Tuesday July 8<sup>th</sup>, 2014

**Objection to Airly Colliery modification 3 – (extending 162/91 consent for a year) due to inappropriate consent conditions for a NPW Act reserve**

**Need to confirm adequate minimisation of subsidence impacts associated with Bord and Pillar Mining Methods**

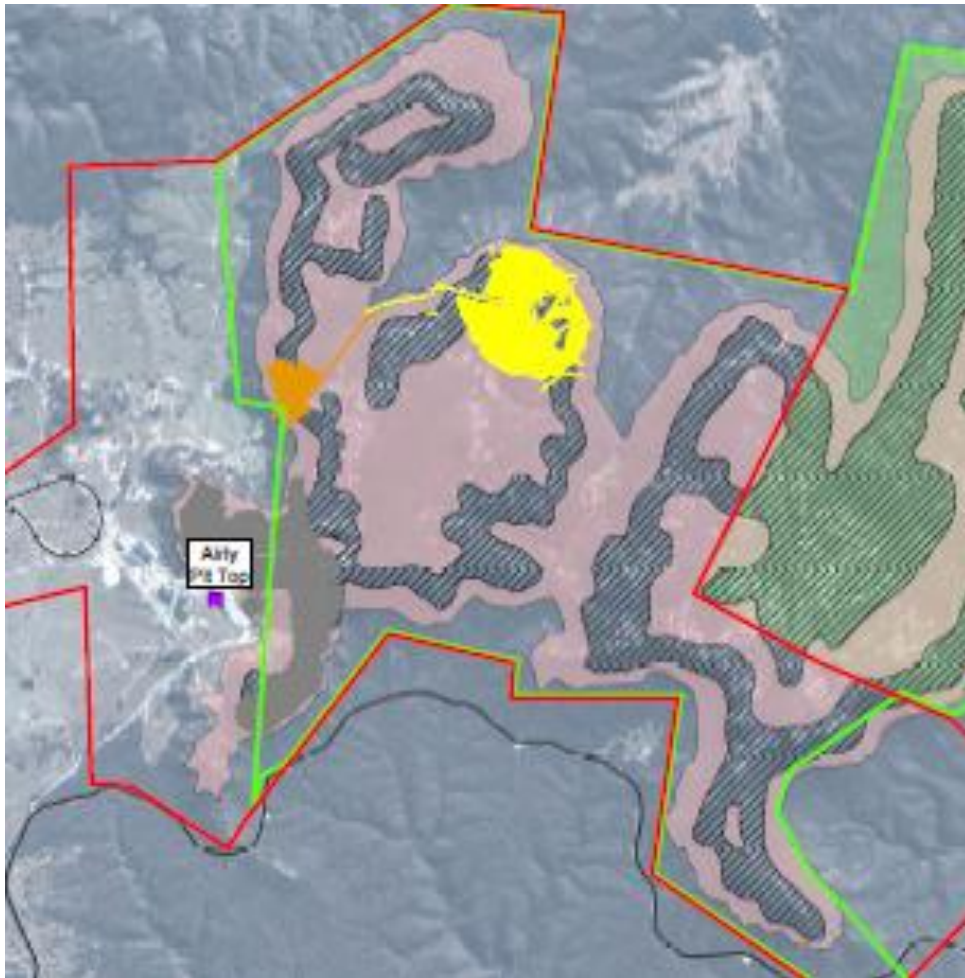
Figure 5 of the EA shows that the bulk of the SCA is not in the so-called ‘protection zones’ (see below). More than three quarters of the mesas will be subsided by 1.8 metres. Where this has occurred elsewhere in pagoda country with longwall mining, this has caused hundreds of cliff collapses and cracking of pagodas (e.g. Angus Place and Baal Bone Collieries).

Figure 5 (above) is deliberately kept vague and at low resolution in the proposal document to hide the enormity of the areas that will be subsided by a staggering 1.8 metres. However, since the Colo Committee knows the area very well, we point out that they will threaten with collapse and cracking. Below shows a series of Google Earth snapshots. The Colo Committee has many slides of most of these areas but does not have digital scans of these, now in the short 2 week timespan have we been able to scan these. Hence I use snaps from Google Earth. It should be pointed out that Google Earth always makes topography look flatter than it actually is. The slopes shown are thus actually steeper. Some key areas in the 1.8 metre subsidence (= collapse and cracking) zone are:

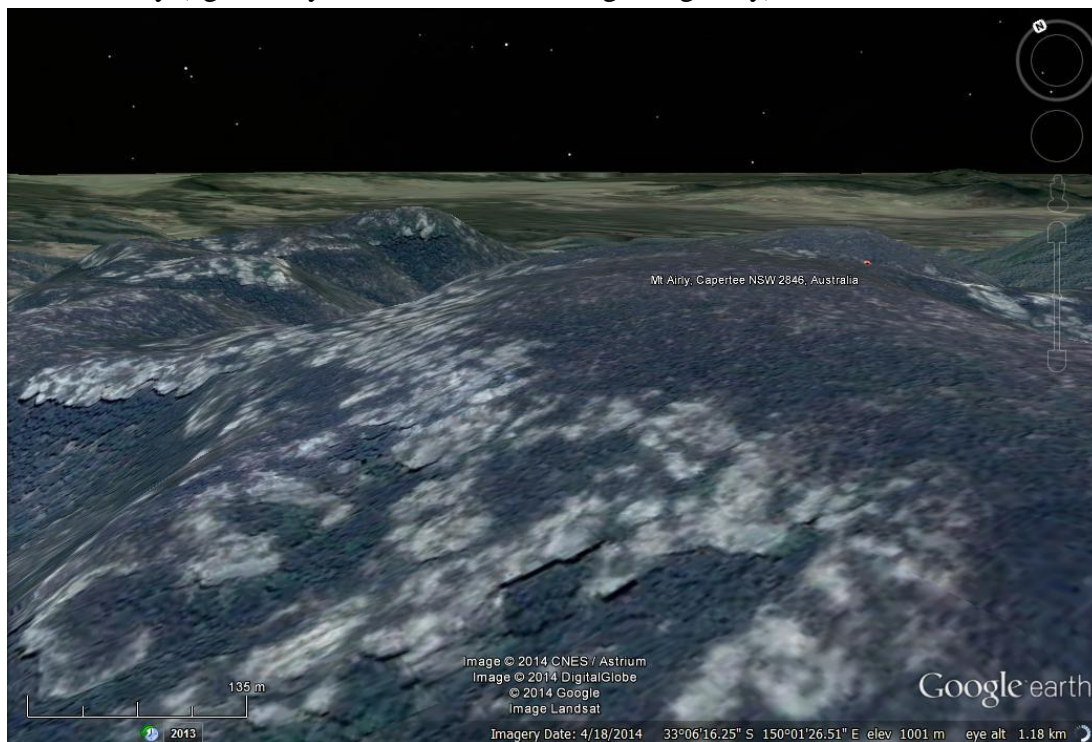
- the smooth pagodas shown below near mount Torbane (visible from Mudgee highway),

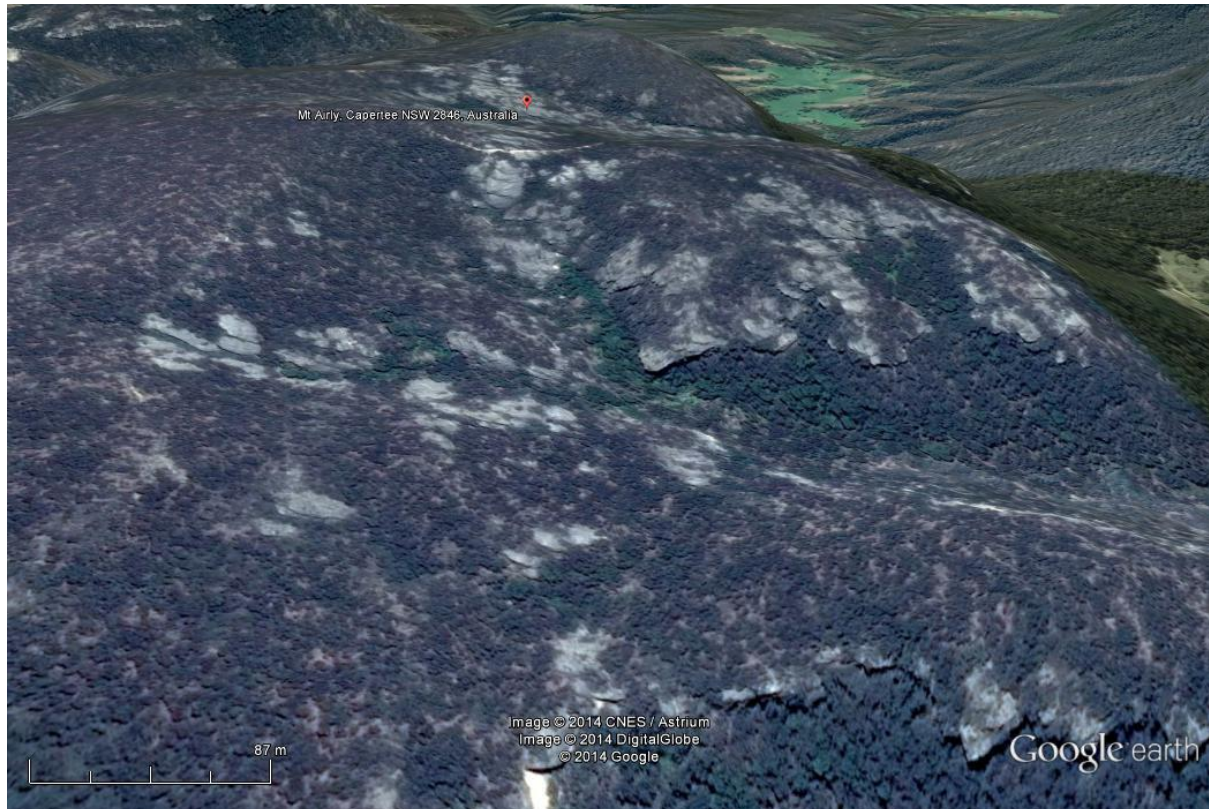
- the vast majority of the superb steeply-sloped pagoda band on the west of Mount Airly (again very visible from the Mudgee highway),

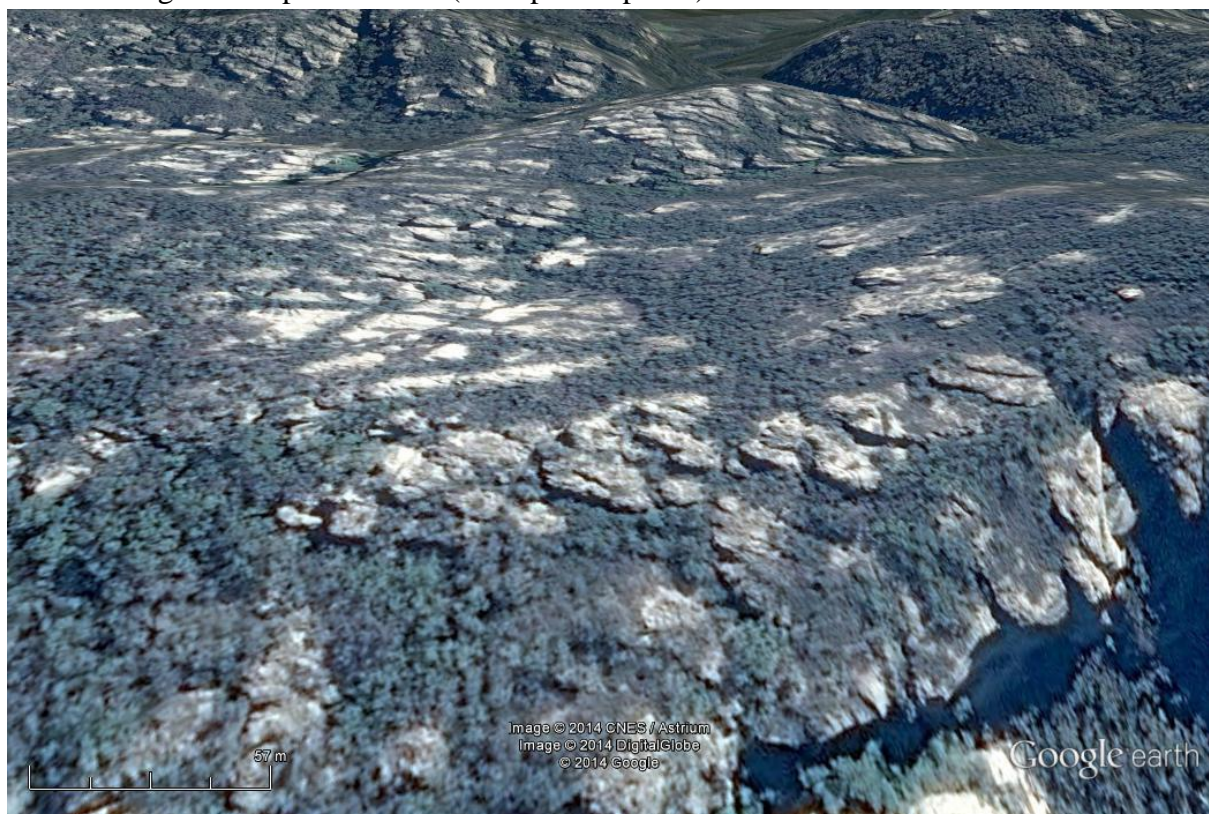
- very steep internal cliff-lines on the east side of Mt Airly (note the tall cliff with shadow is in the 1.8 metre subsidence zone and will almost certainly collapse)

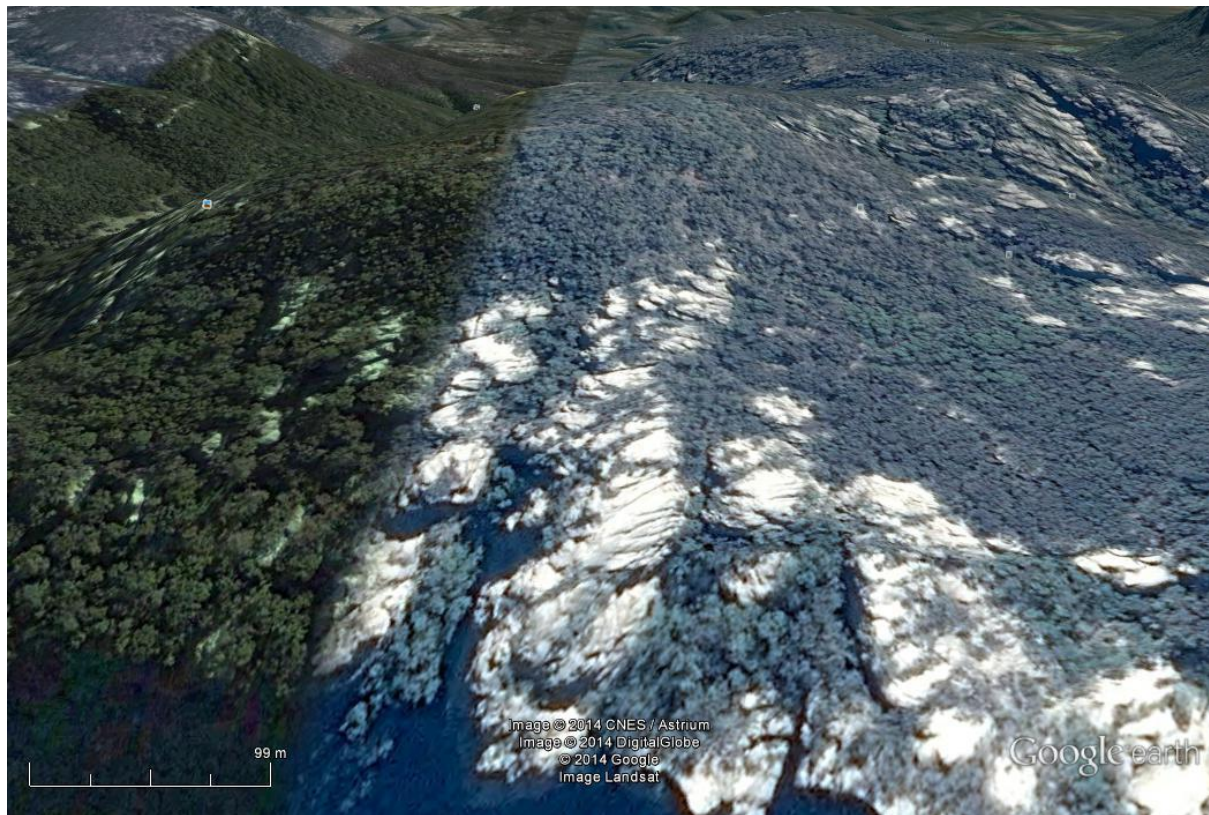
- pagodas east of Genowlan Mountain trig, note cliffs and caves shown in shadow in Google Earth photo below (front part of photo)

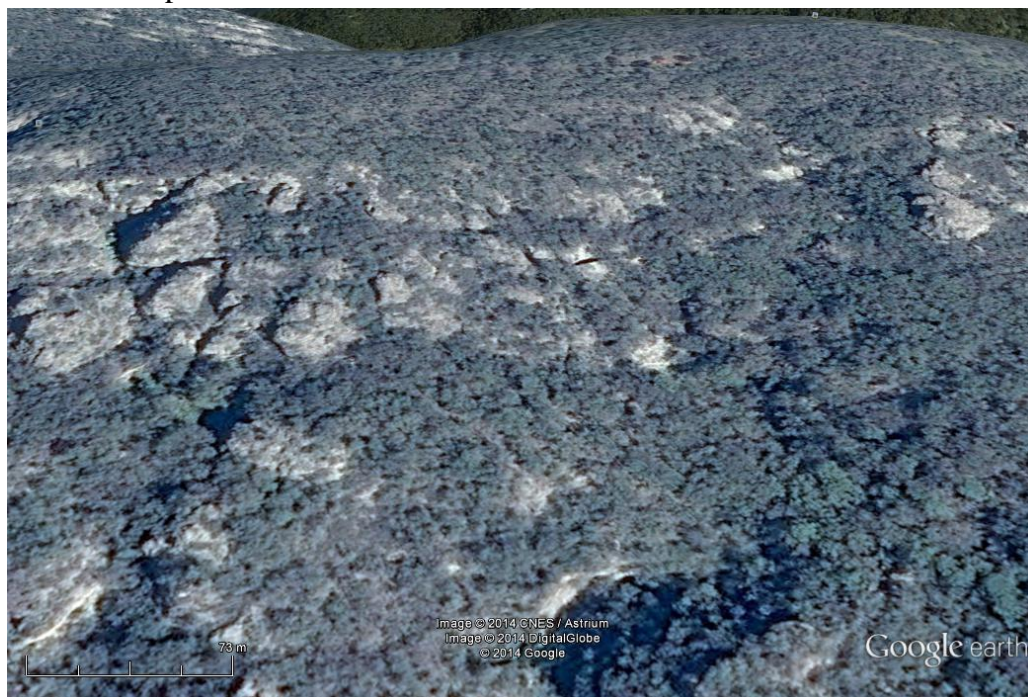
- pagodas west of 'Pappy's Pass' (where the road from Col Ribaux's property emerges on the south of the plateau). Note the deep canyon marked with trees in centre-photo that passes through the pagoda complex and will likely be shattered and collapse.
